Recommendation Report for Planning Permission for Works or Extension to a Dwelling

REF NO: BR/254/21/HH

LOCATION: 3 Nelson Road
Bognor Regis
PO21 2RY

PROPOSAL: Erection of first floor side extension.

CLIENT	Mr & Mrs J Landreth	DRAWING	002 Proposed Floor Plans	
SITE	3 Nelson Road, Bognor Regis	DATE	28 10 21	AUTHOR AH
PROJECT	Proposed Extensions & Alterations	SCALE	1: 100 @ A3	STATUS PL

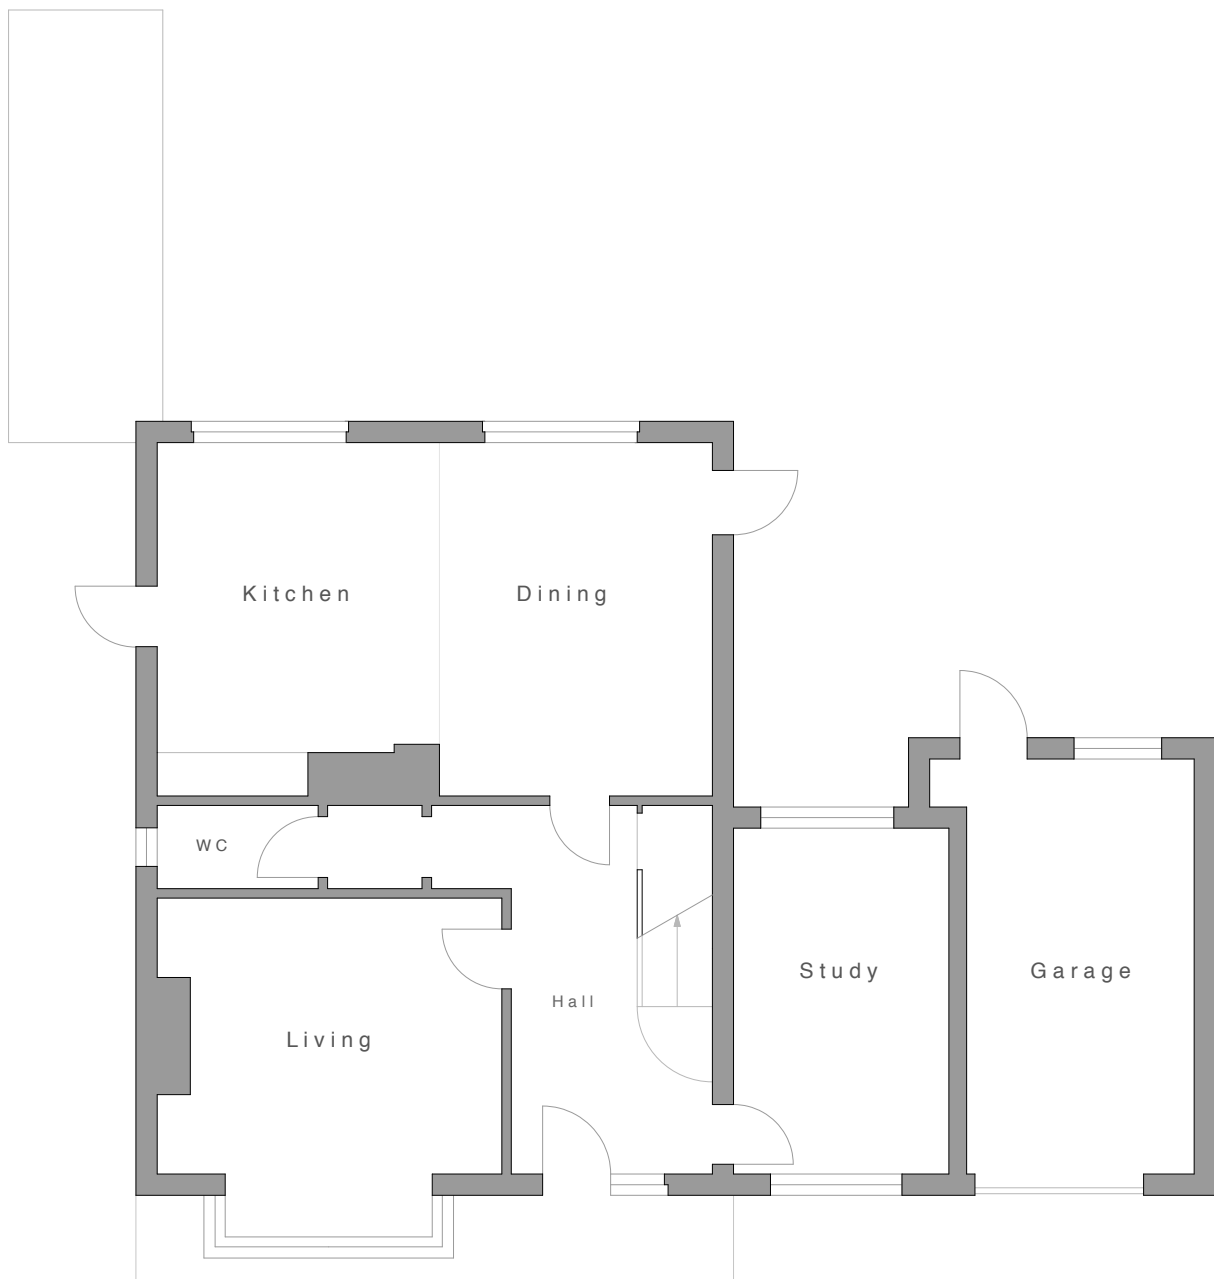
The proposal will construct a first floor above the garage. This extends along approximately half of the side elevation of the dwelling. This does add bulk to the dwelling however appears acceptable scale and does not appear out of character with the properties within the street scene.

There will be an two additional windows to the first floor which face the rear. This serves a bedroom and a landing. Due to the siting of the windows and properties to the east and west, views over the gardens at these elevations will be minimal. There will be views towards the property and garden at the rear which has a short rear garden. However ,views are not considered additional to that which are already achieved from the existing rear facing windows which are situated further south than the proposed.

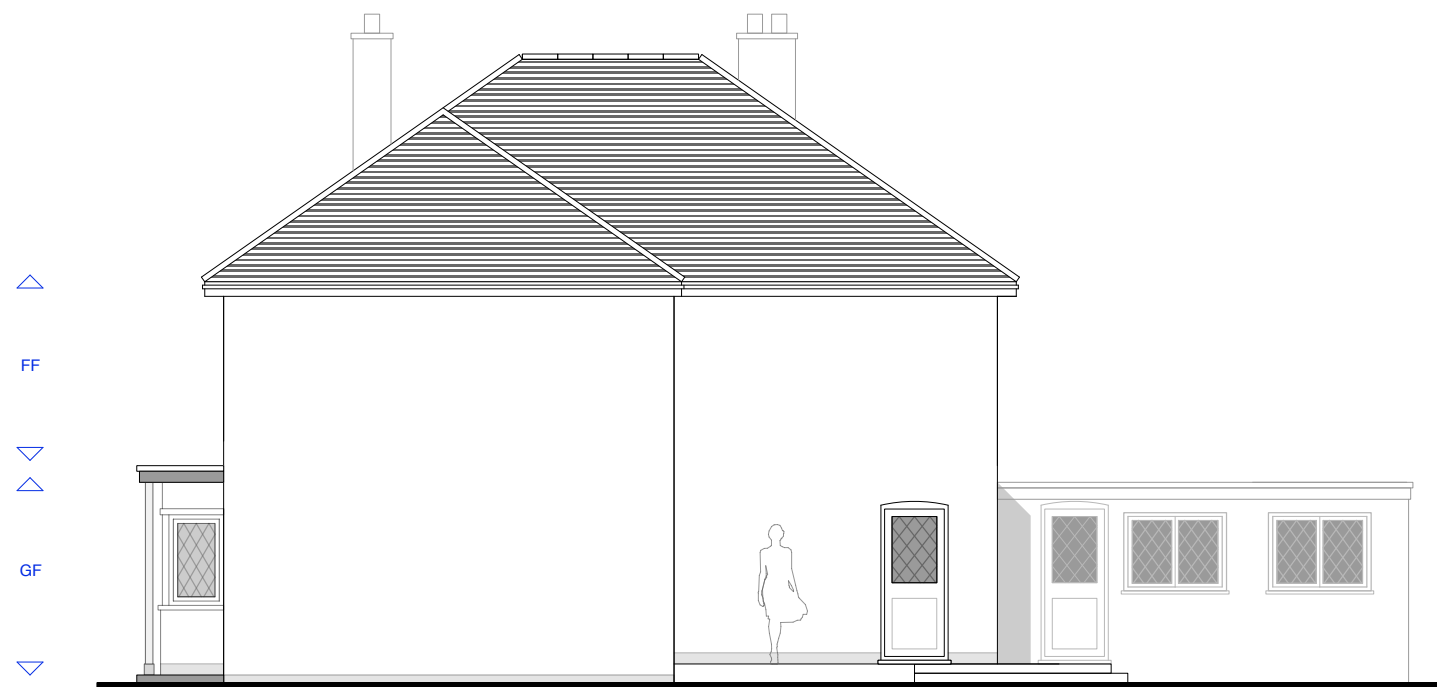
The extension will have a hipped roof. This matches that of the host dwelling and with the height of the eaves matching that of the dwelling, the addition appears well integrated and sympathetic in design to the host dwelling. Materials will match the host dwelling ensuring the development is visually integrated.

The Arun Design Guide states 'Positioning extensions below the roof ridge line of the existing property will also help to create visual subservience' 'Side extensions should also in most cases be set down from the existing roof ridge height by a minimum of 0.5 metres'. The proposal is set below the ridge height of the dwelling which helps the extensions appear subservient. 'Extensions must not close important gaps in the street scene by leading to a terracing effect.' The proposal retains just under 1m to the boundary. However this is the same as the existing footprint and due to the siting of the properties, does not result in a terracing effect.

The addition of a first floor will sit above the garage and retains the existing footprint with a length of 6m and a width of 6.25m. The height will increase from 3.9m to 7.5m.

The addition retains around 0.8m to the boundary although around a further 4m is retained to the side elevation of the neighbouring property at No.5. Due to the separation between the development and the neighbouring dwelling, the addition is not considered to give rise to adverse overbearing or overshadowing. There is a window to the eastern side of No.5 however this appears obscured glazed and with separation retained, impacts are not considered significant.

There will also be 2 front facing windows although views will be of the street scene.
